County of Bernalillo
State of New Mexico
Public Works Division

Subject: Avanzando Draft Traffic Impact Study

Below are Bernalillo County comments on the subject draft TIS dated March 18, 2022. Please address these comments for the subsequent submittal.

Following is the updated proposed site development plan depicting the driveway (access) location (see Appendix Page A-4). See Appendix page A-3 for the old 2017 site plan.

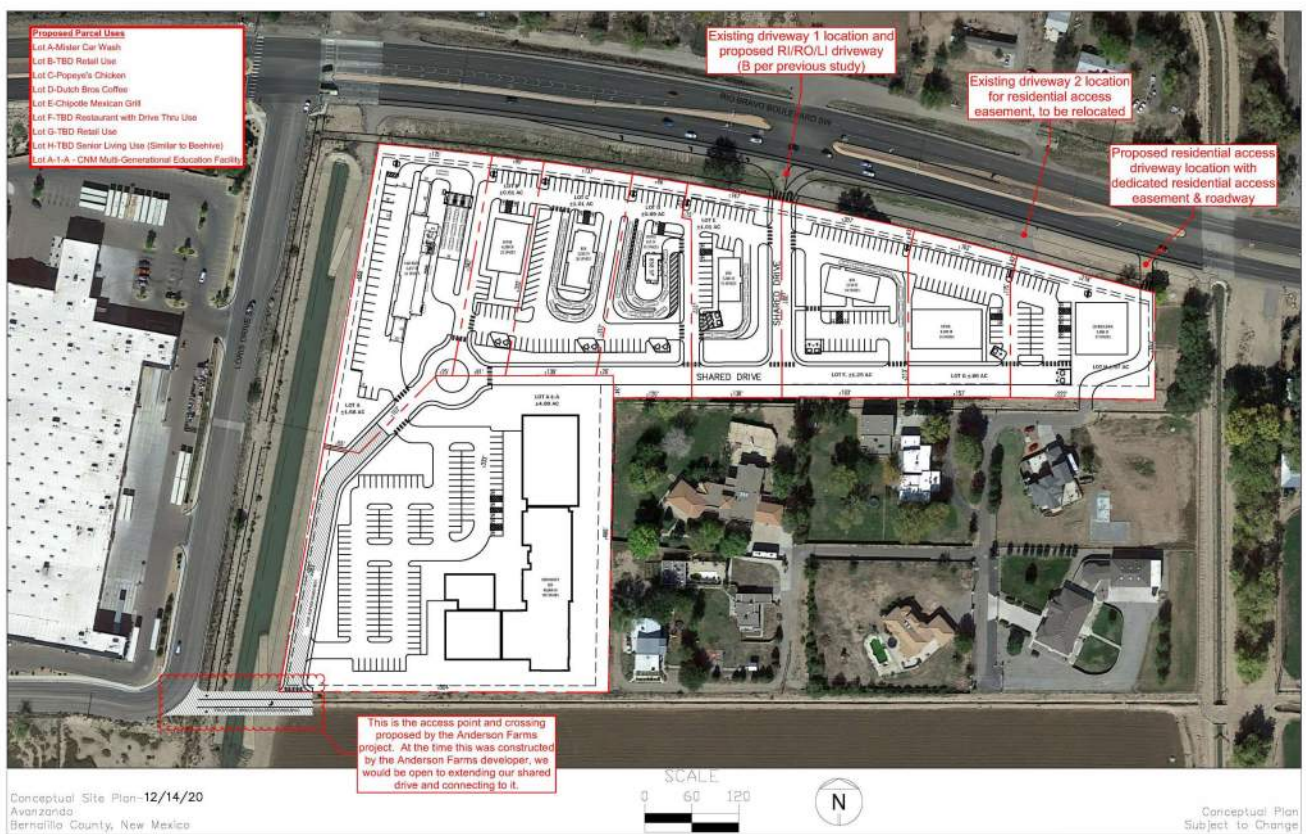
3. Page 4 Description of Proposed Development – Property is zoned C-1, Neighborhood Commercial. Correct the zoning and remove language about a special use permit. (Previous comment)
4. Page 5 Other Developments or Transportation Projects – Include Bernalillo County’s adaptive signal project for Rio Bravo Blvd. This project is currently under construction. Project TIP page is attached.
5. Page 6/A-103 – Streetlight data was provided for La Junta only. These data are missing for Sunstar.
6. Page 13/A-25 & A-26 – Historical Growth Rates. Pages A-25 & A-26 provide the Travel Demand Model from the 2035 MPT showing model output for 2015 and 2035. The narrative describes using the 2040 Update MTP travel demand model. It appears that the most recent MTP was used for these growth rates. Update the appendix accordingly.
